## **TOWN AND COUNTRY PLANNING ACT 1990**

### **FULL**

**Reference:** H16-0542-16 **Date of Decision:** 25th August 2016  
**Applicant:** Mr G & D J Winyard  
C/O Winyard Engineering Ltd  
2/3 Cresswell Close, Wardentree Lane  
Pinchbeck  
Spalding Lincs  
PE11 3TY  
**Location:** 36 Holbeach Road Spalding  
**Description:** Construction of six two-storey dwellings

15/1257-02

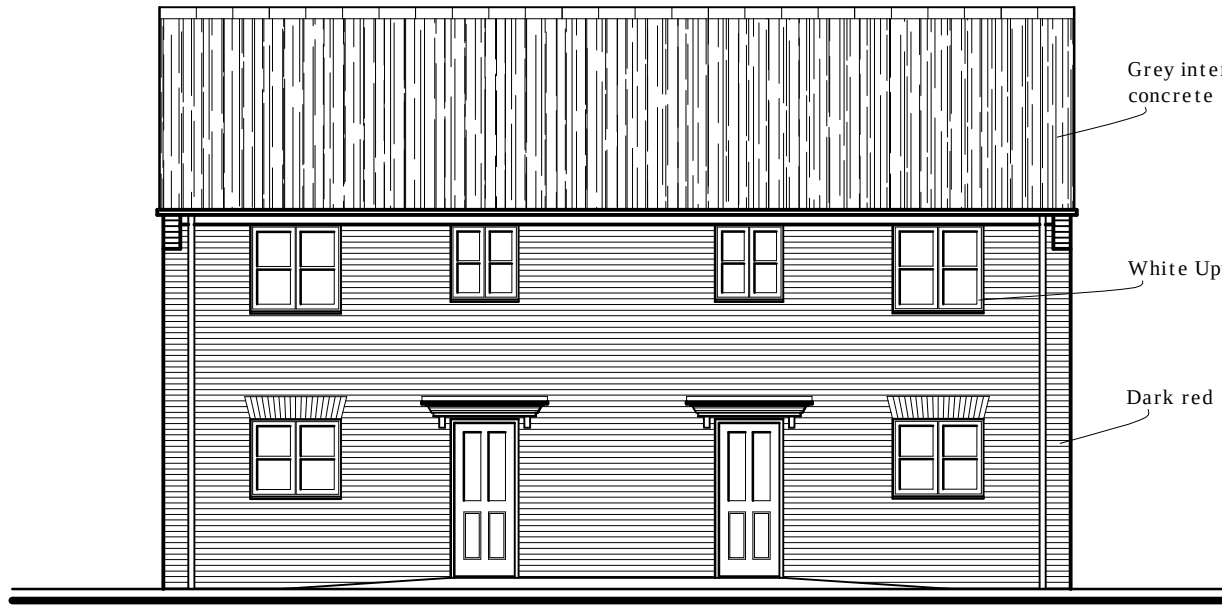
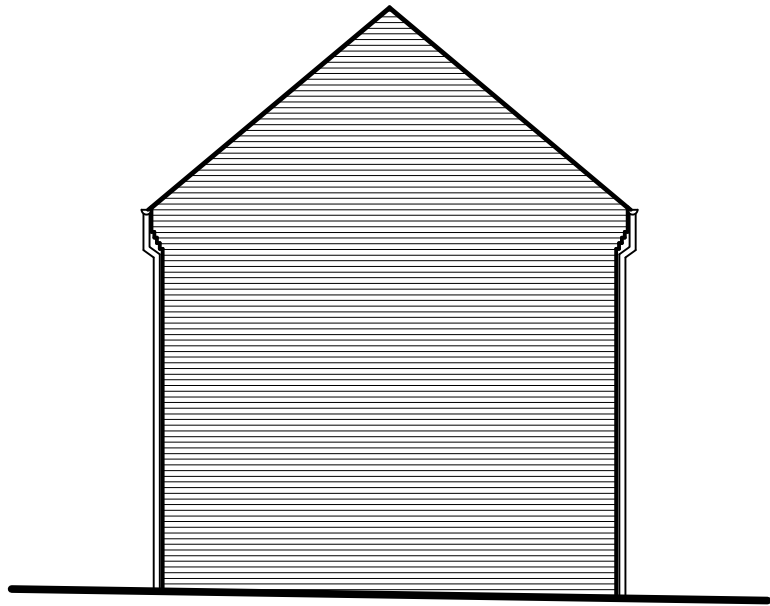
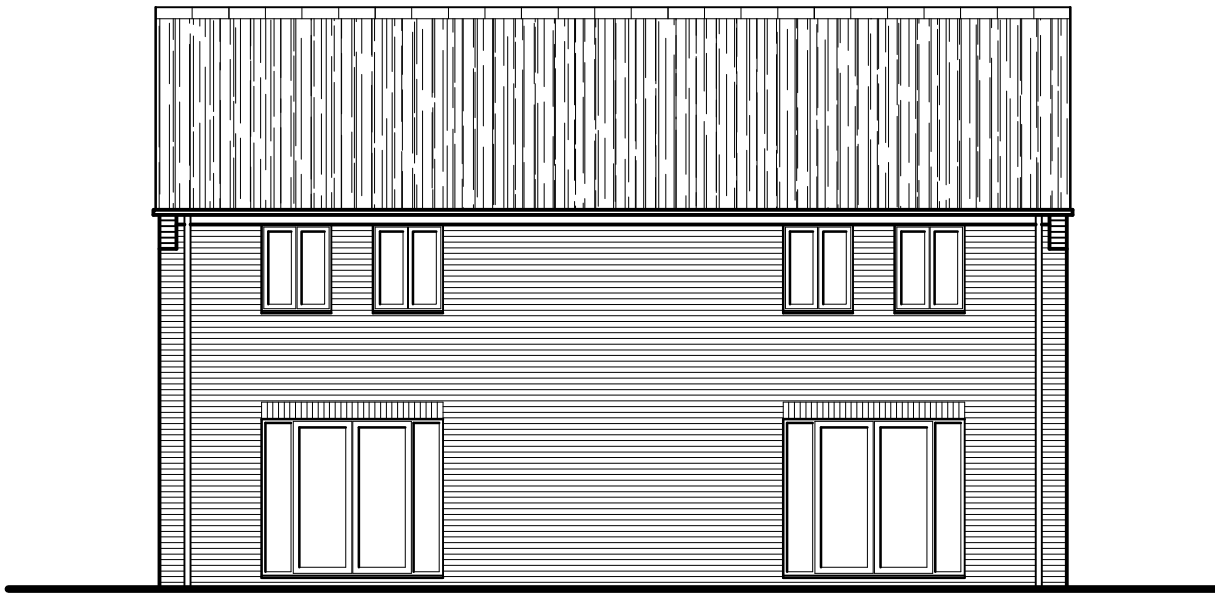
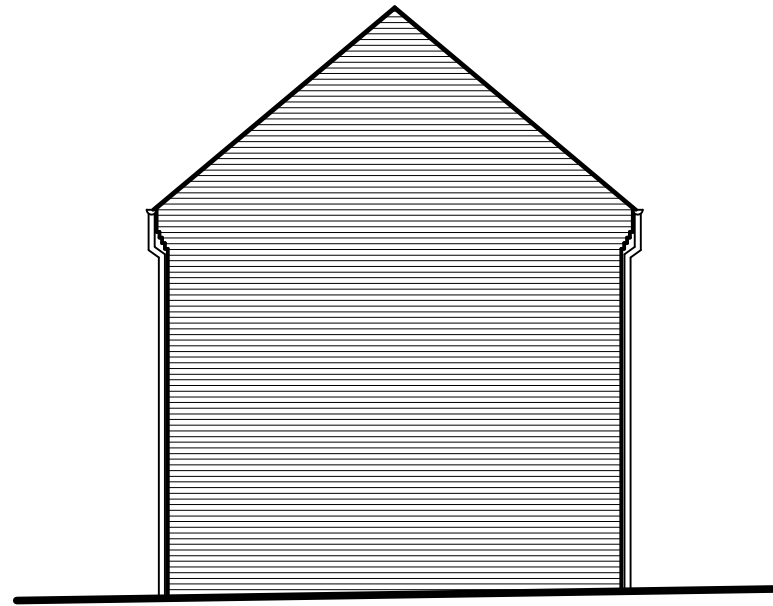
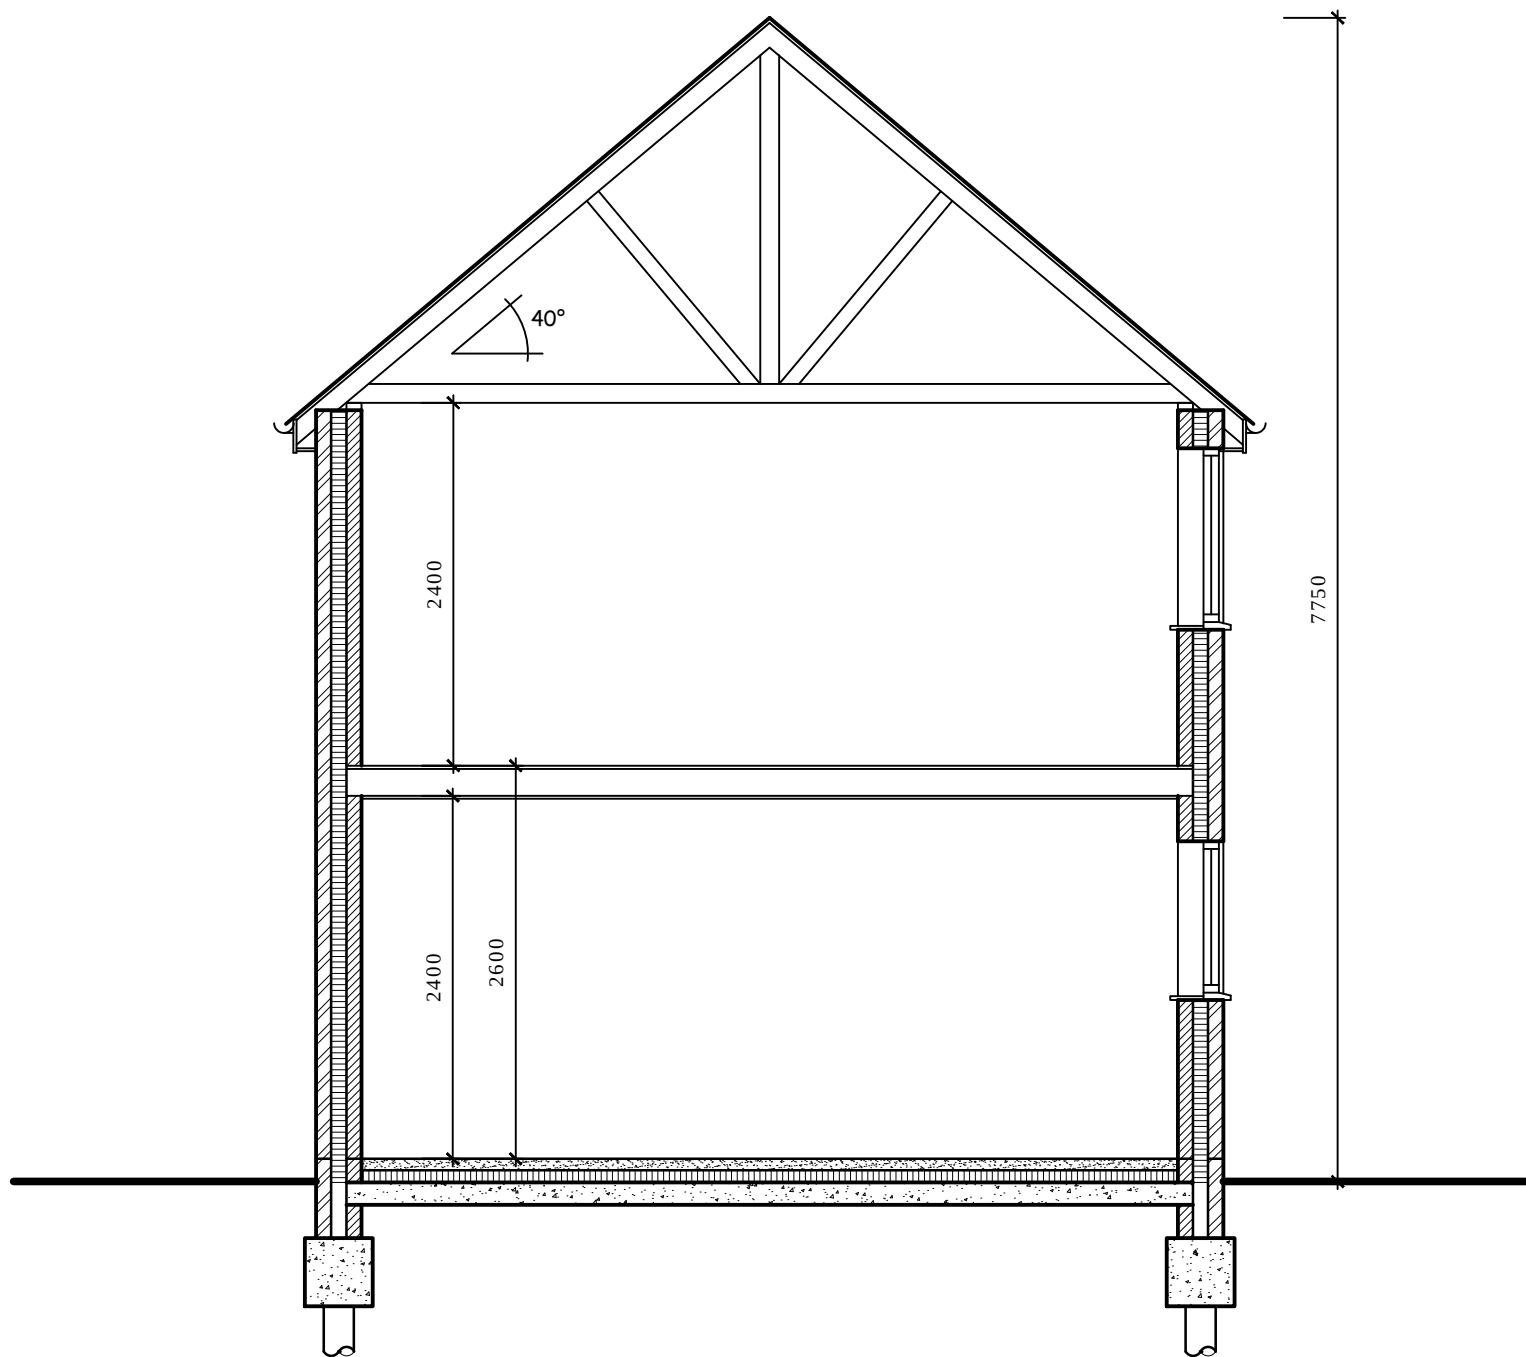
- 1 In its present form, the development as proposed would not adequately address flood risk concerns. There is a need to raise finished floor levels to a minimum of 1 metre or above to adequately address flood risk concerns on this site. It is considered that this raising of levels would constitute an incongruous and visually harmful form of development that would be at odds with the character of the surrounding area and adversely impact upon the residential amenity of adjacent properties. As such, the proposal is considered contrary to Policies HS4, SG14 and S17 of the South Holland Local Plan, 2006. These policies indicate that new development will be permitted on suitable sites in Spalding and Area Centres and should make a positive contribution to the character and appearance of the locality and that do not impact negatively on existing residential amenity. They are in accordance with guidance within the National Planning Policy Framework (2012), particularly section 7 which seeks a high quality of design.
